CITY OF ALBUQUERQUE

**Re: Dave and Buster's
2100 Louisiana Blvd NE
Request Permanent C.O. - Accepted
Engineer's Stamp dated: 9-10-14 (J19D038)
Certification dated: 8-29-16**

**RE: Winrock Redevelopment Dave and Busters
Grading and Drainage Plan
Engineers Stamp Date 9/10/14 (J19D038)**

**RE: Winrock Redevelopment Dave and Busters
Grading and Drainage Plan
Engineers Stamp Date 8/14/14 (J19D038)**

SHEET NO. AS-101

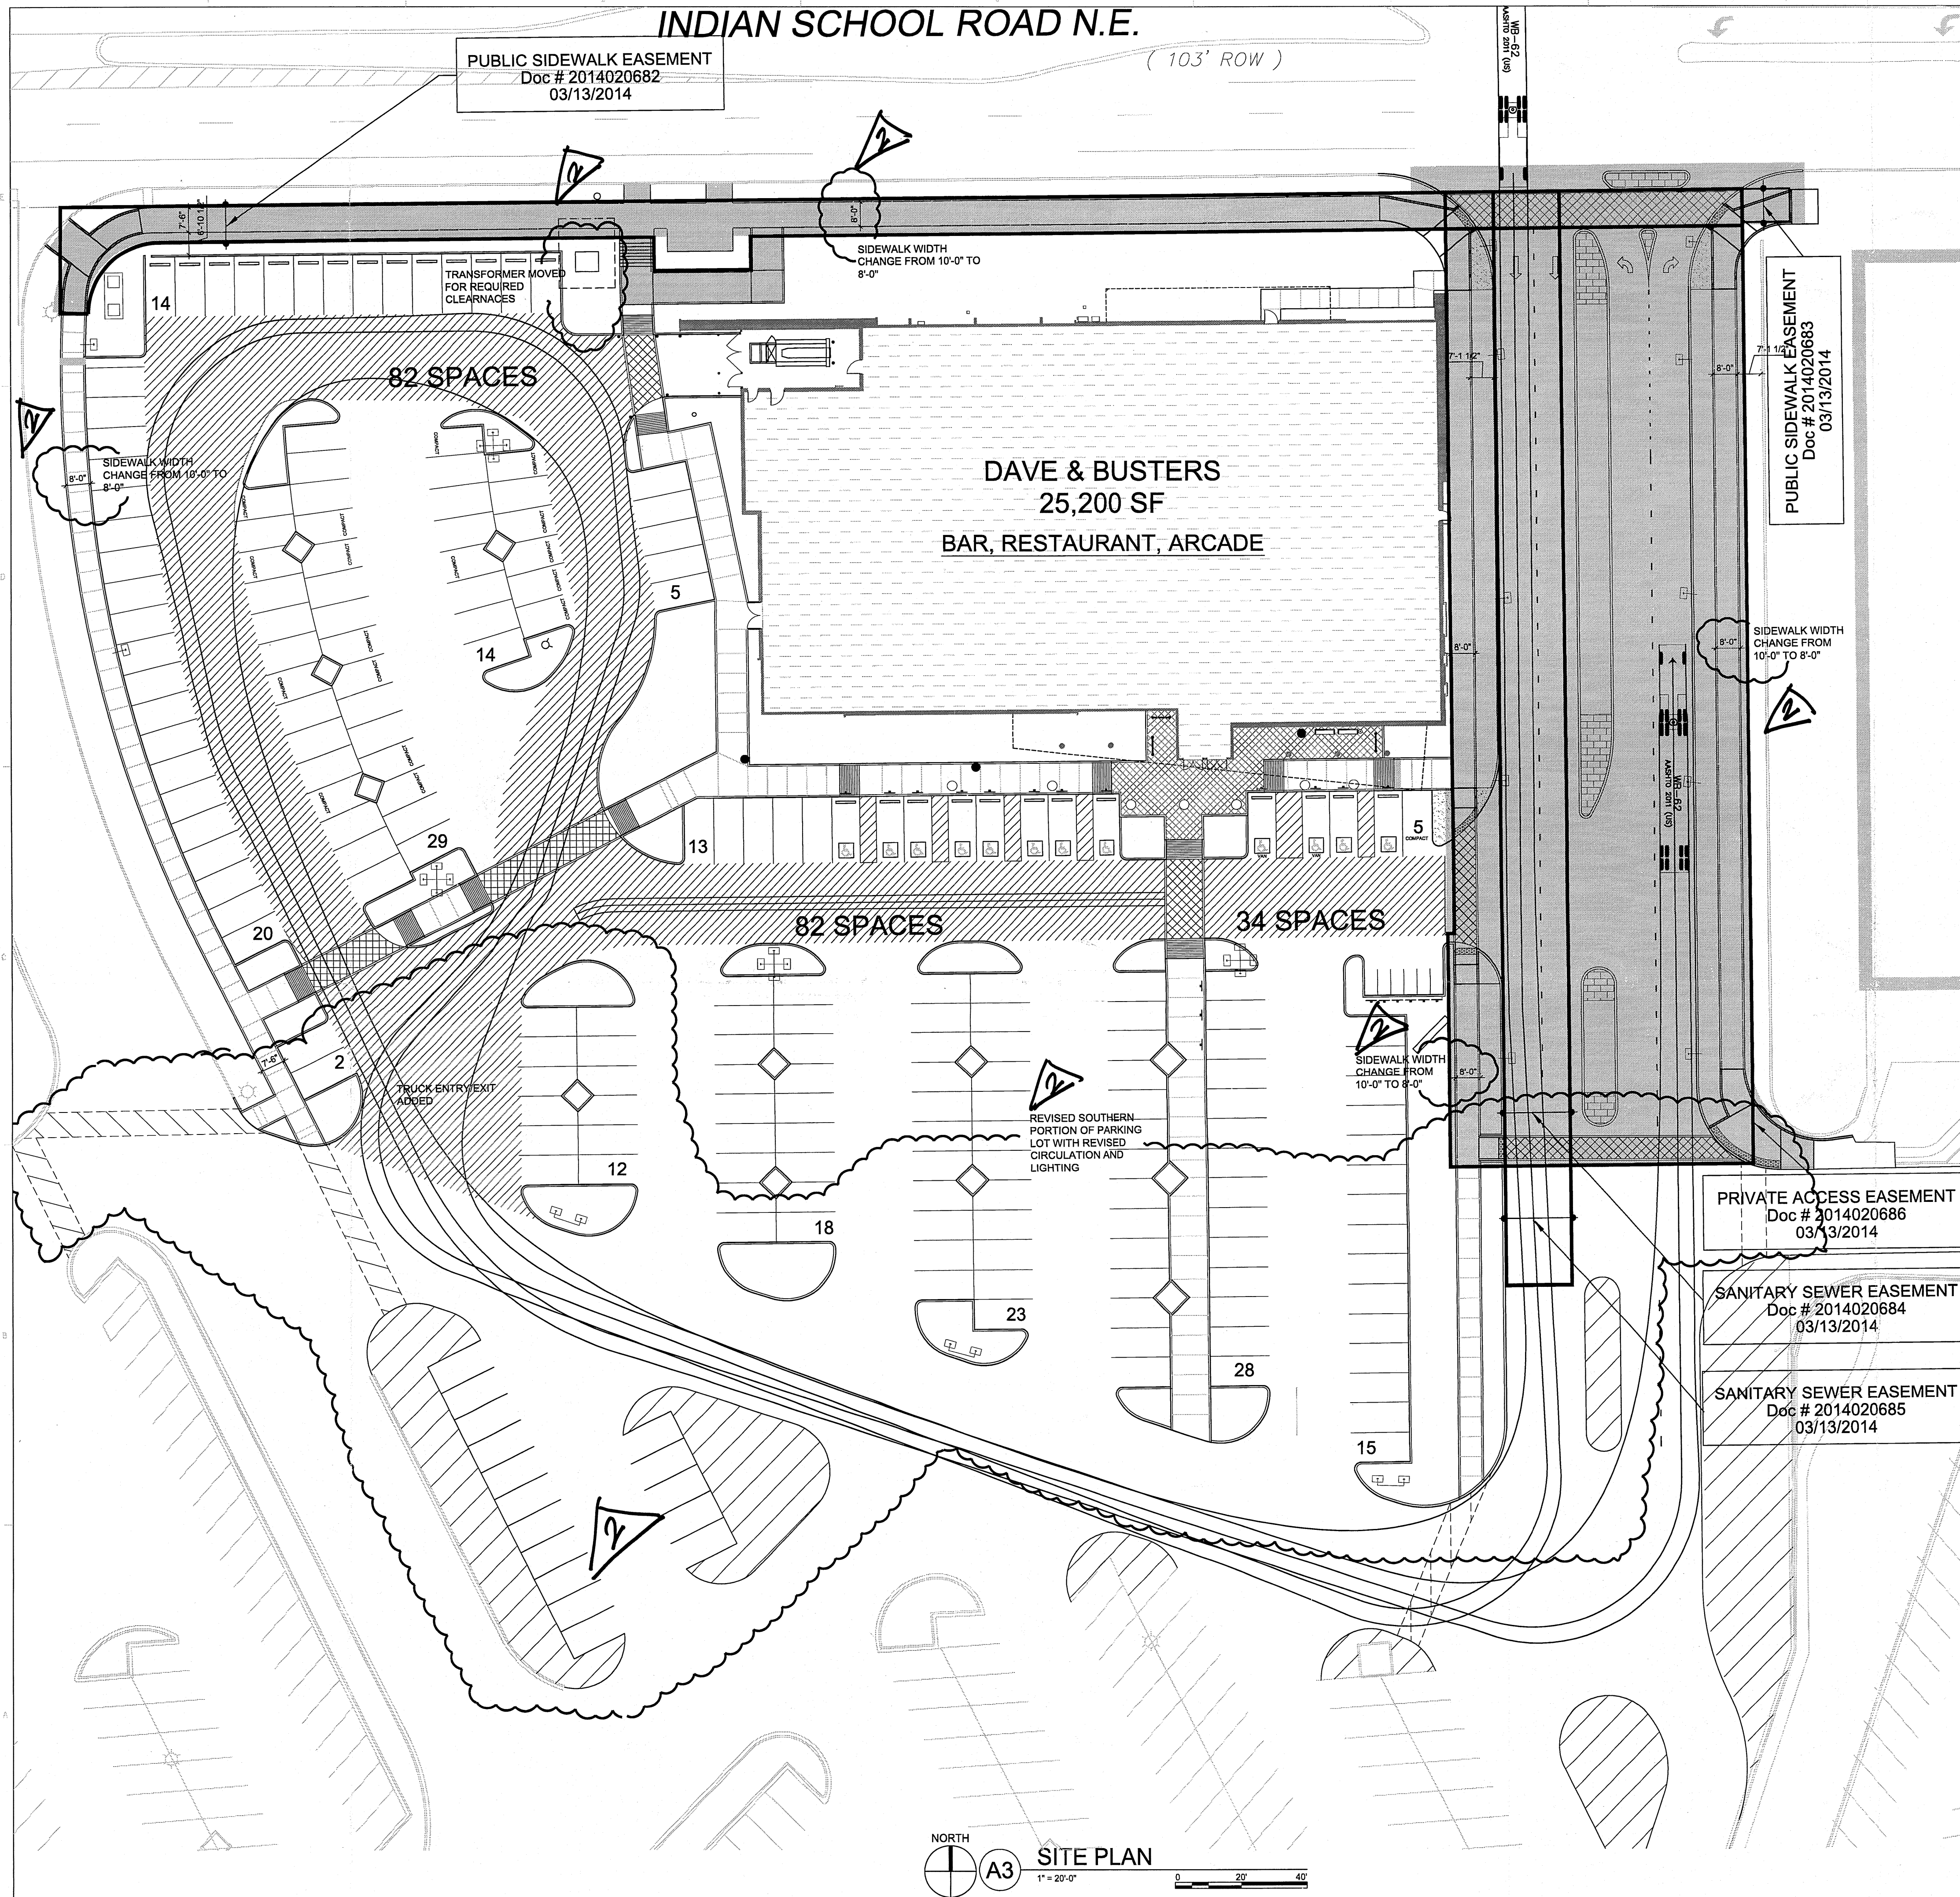
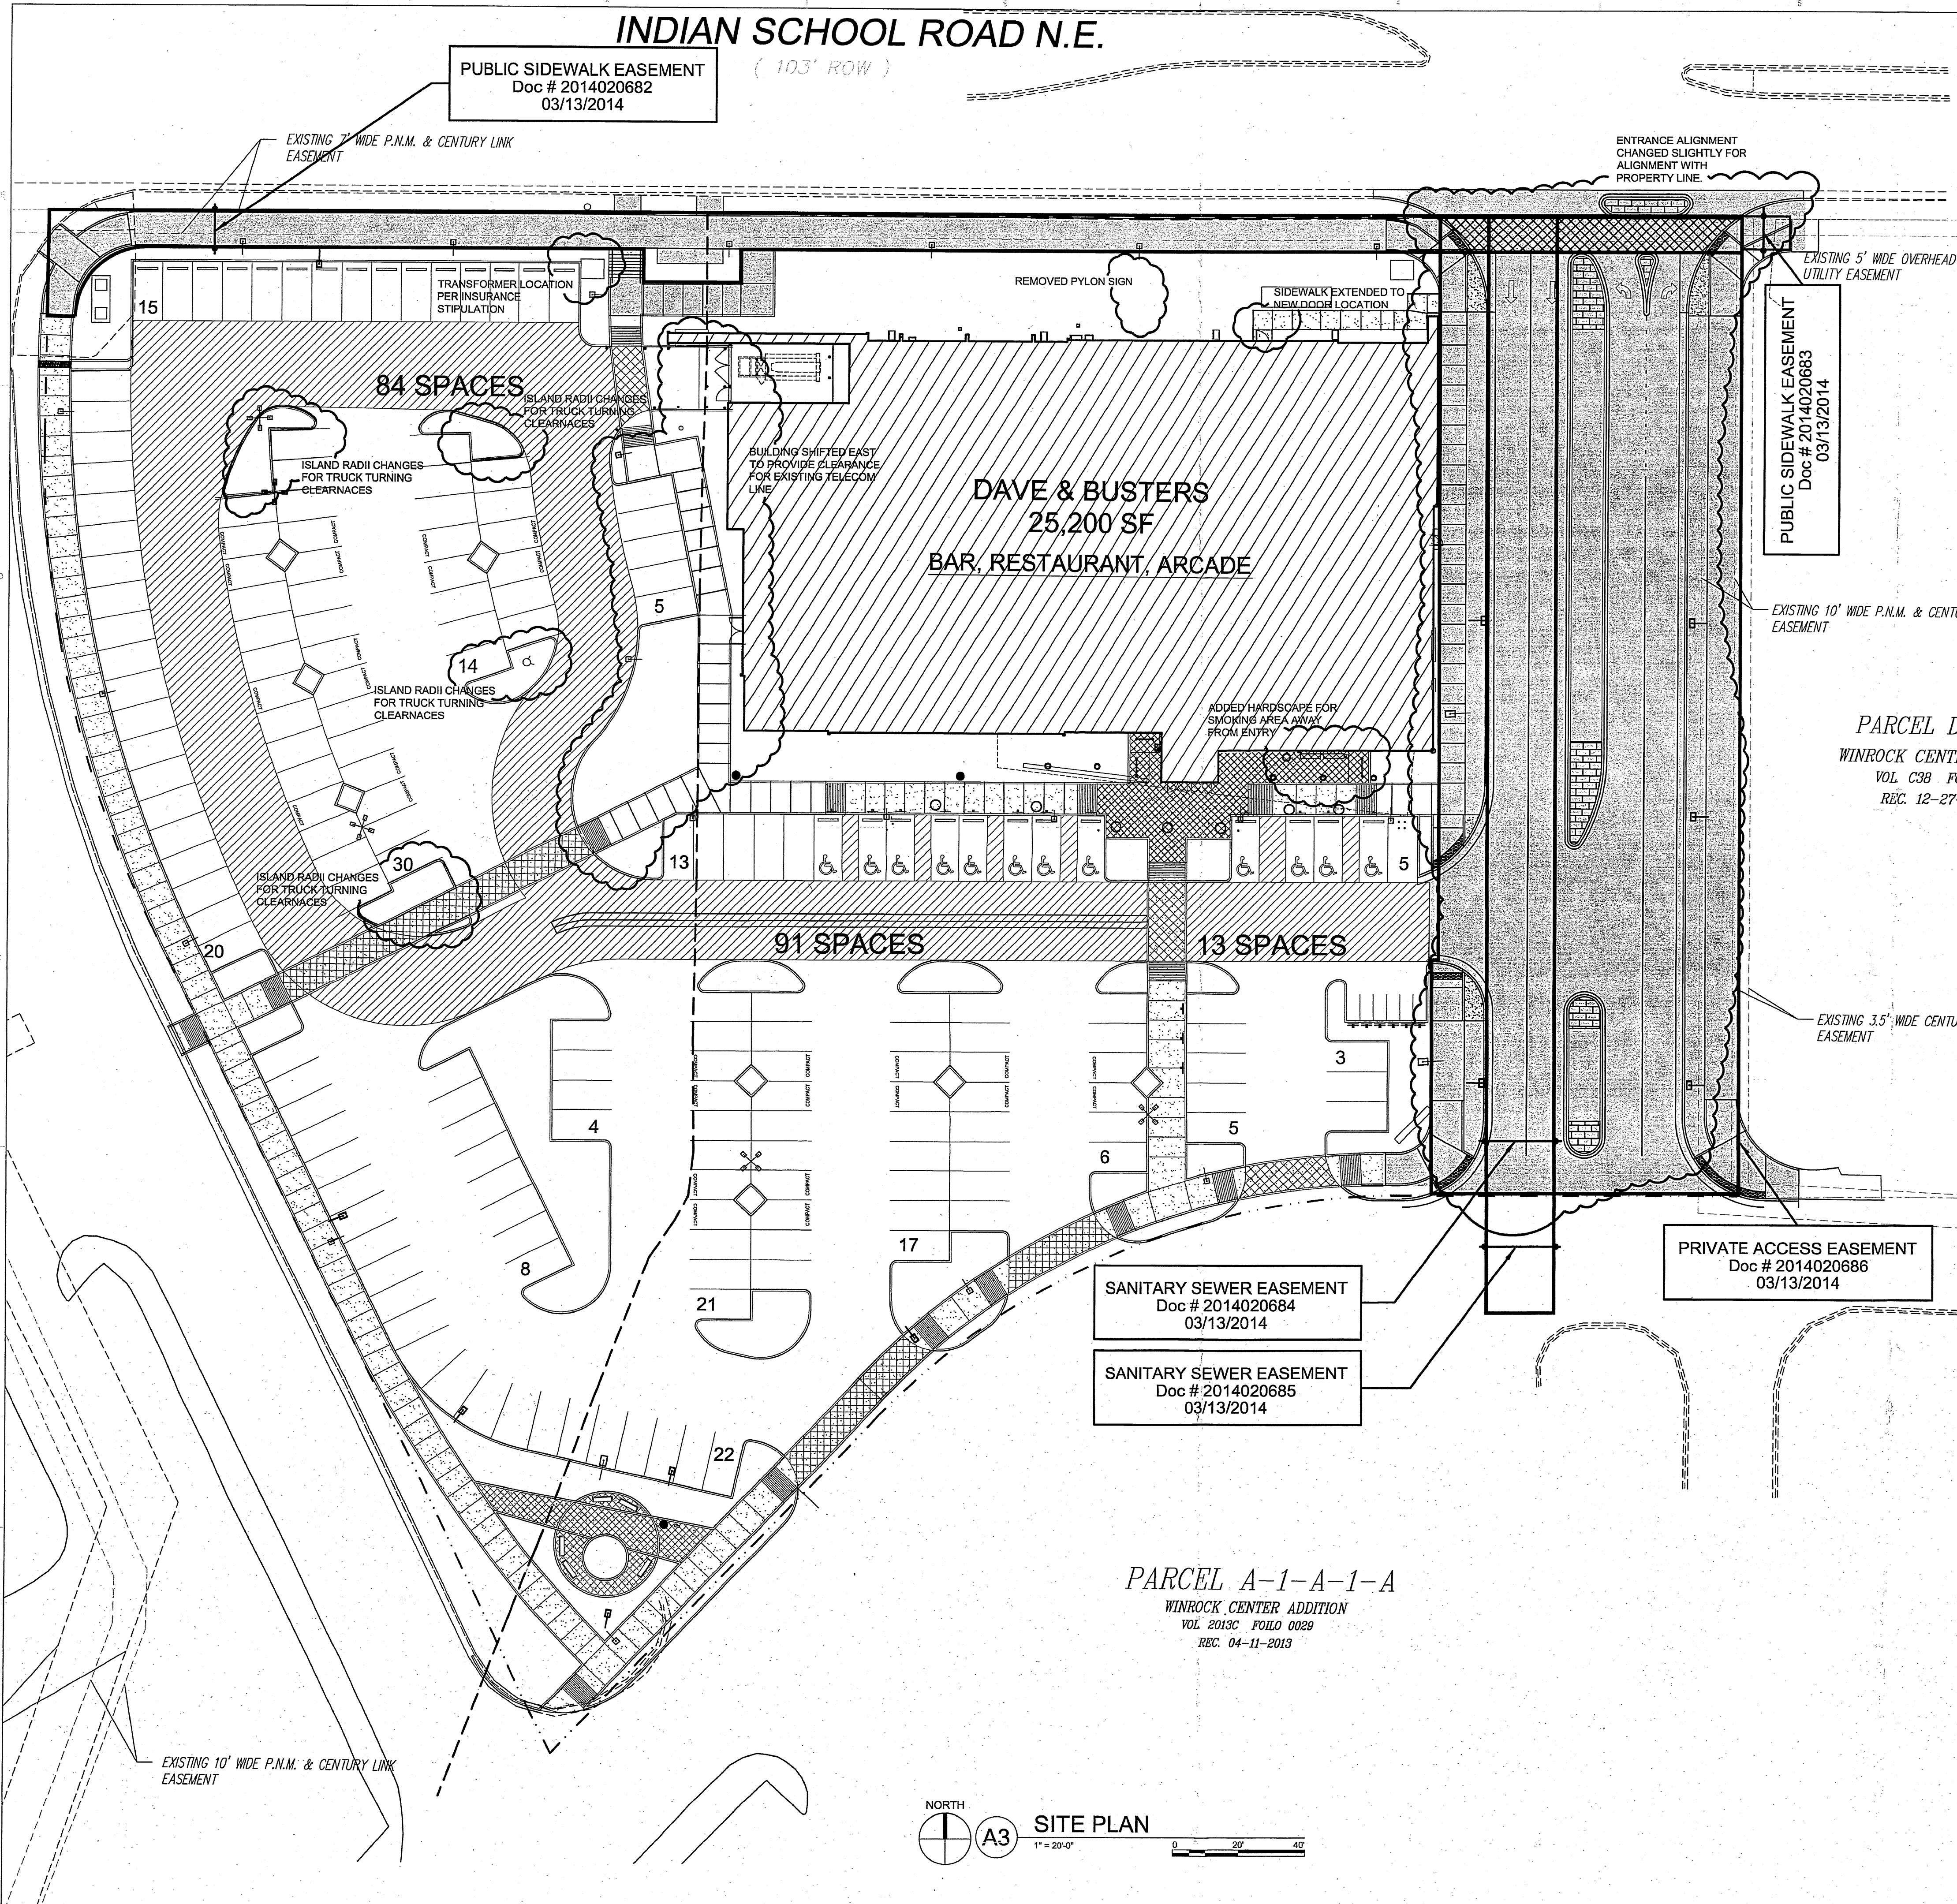
- ADA accessible parking spots need to have designation signs installed.
- Bicycle racks need to be installed.
- Clear the site of construction equipment and materials.
- Sidewalk is missing near the wheelchair ramp at the northwest corner of the site.
- Telephone poles along Indian School need to be shown on redlined plan and sidewalk needs to be repaired at the locations where it was damaged.
- Handrail needs to be installed at stairs located along Indian School Rd.
- Landscaping has not been completed.
- Work Order must be completed before a Permanent Certificate of Occupancy can be issued.
- Signage and barricading must be in place to discourage drivers from turning into the drive on the east side of the site while under construction.
- There is a large volume of sediment flowing into the public right-of-way. Appropriate SWPPP and sediment control needs to be in place.
